Subject: FW: CM/17/21/PL land at Wren Cottage

Further to my email below, I have visited the site from the rear of properties in Wooldridge Walk and can now provide full comments on the proposals.

PLOT 2 FLOOR PLANS
SCALE 1:100 @ a3

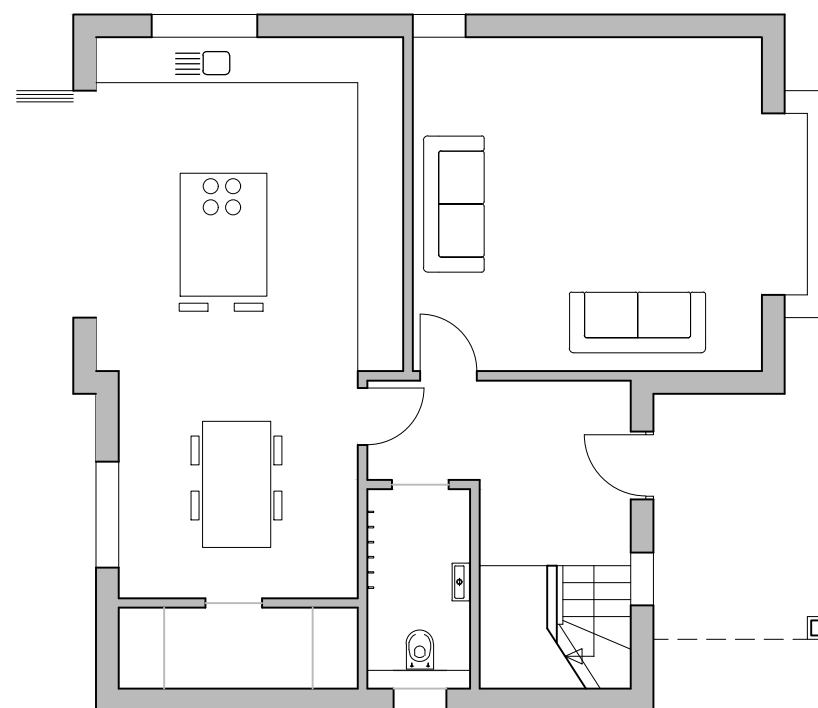
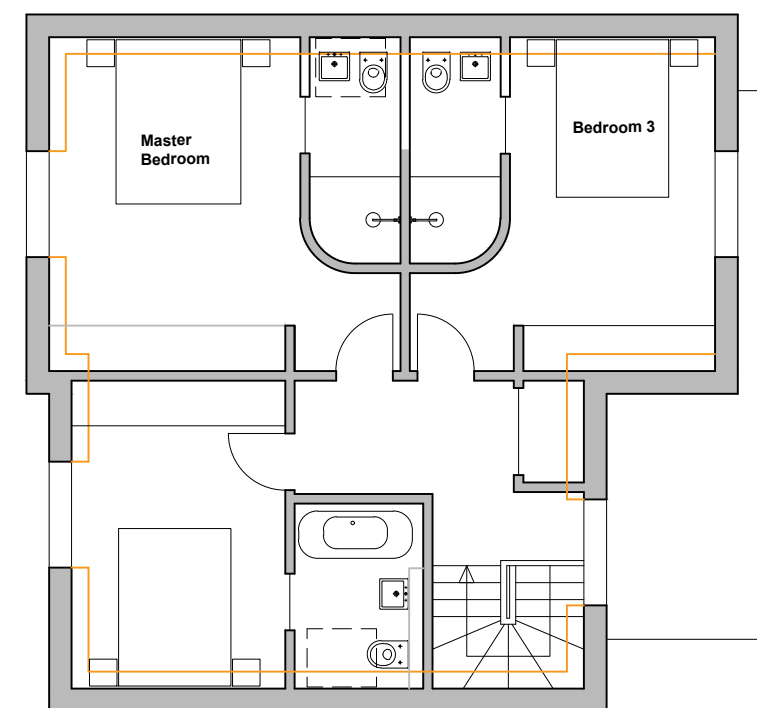
No properties are 12m from the site boundary and the relationship is not to two-storey dwellings to the west. There are unacceptable relationships proposed between the proposed and existing dwellings. The distance to the rear of no.5 is only 15.6m and to no.7 only 20m. The distance to no.6 and no. 4 is only 22m – whilst this is marginally above our guidelines, the relationship is a two-storey dwelling to a single storey dwelling and therefore an additional allowance should be included (especially as the properties are not a minimum of 12m from the boundary).

I will be recommending refusal of the proposals as they currently stand. In order for a scheme to be considered favourably, I would suggest that Plots 2 – 4 are proposed without first floor windows to the rear and are significantly reduced in scale so that they are 1 ½ storey maximum height.

Whilst I consider that you have addressed the relationship issue with 30 Appletree Walk, I do not consider that the relationship from plot 2 to properties in Wooldridge Walk has been satisfactorily addressed. I need to look at this properly on site but I'm not convinced that this relationship is satisfactory. This could be overcome if Plot 2 was a bungalow. Would you be prepared to amend the scheme this way? If so, I could take the application to committee on 28 July with a favourable recommendation.
